Date: 15-Nov-2018
Our Ref: 2018/93395

**Discharge of condition 8 (outdoor lighting) on previous premission 2015/91261 for
erection of 2 storey annex forming 4 residential respite care apartments
Adj,106, Royd Street, Milnsbridge, Huddersfield, HD3 4RB
Application Number: 2018/93395**

PROPOSED FRONT ELEVATION (FROM ROYD STREET)
SCALE 1:100 AT A3

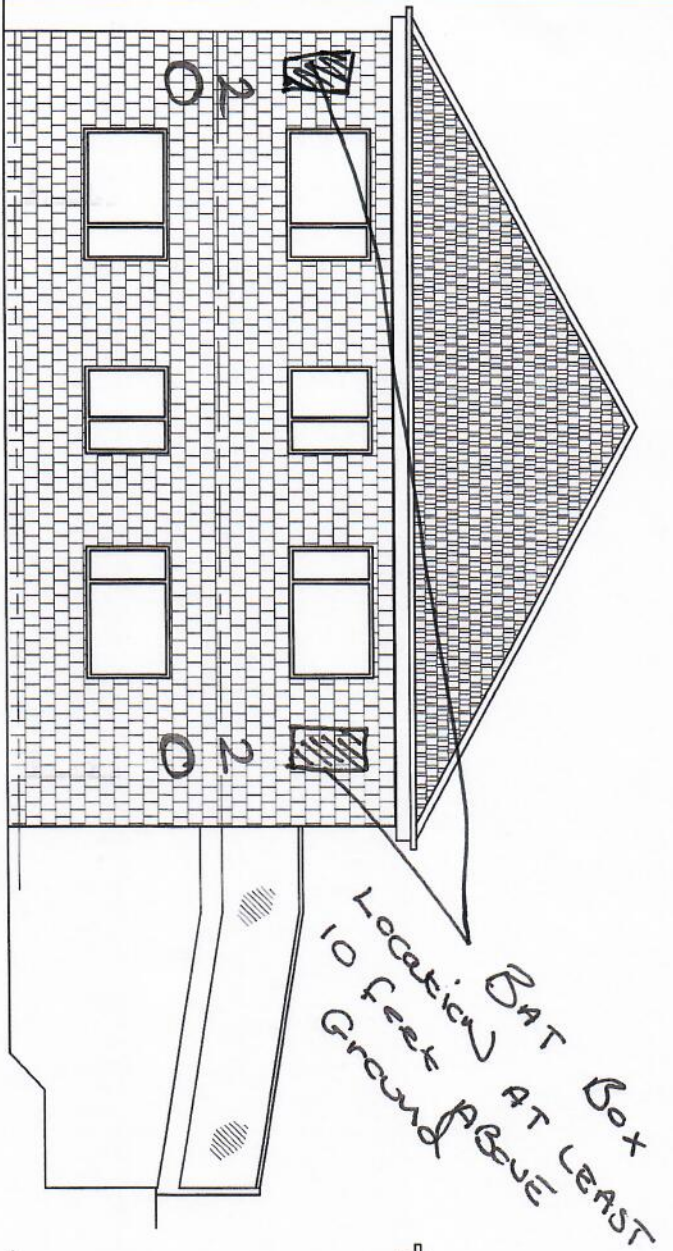
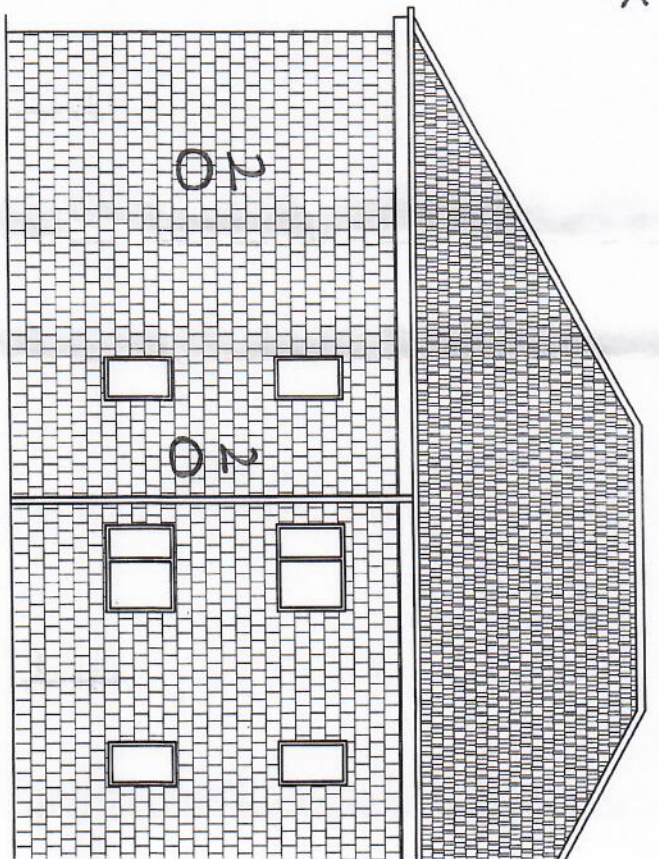
These details are acceptable subject to the amended location of the lights in accordance
with the enclosed drawing.
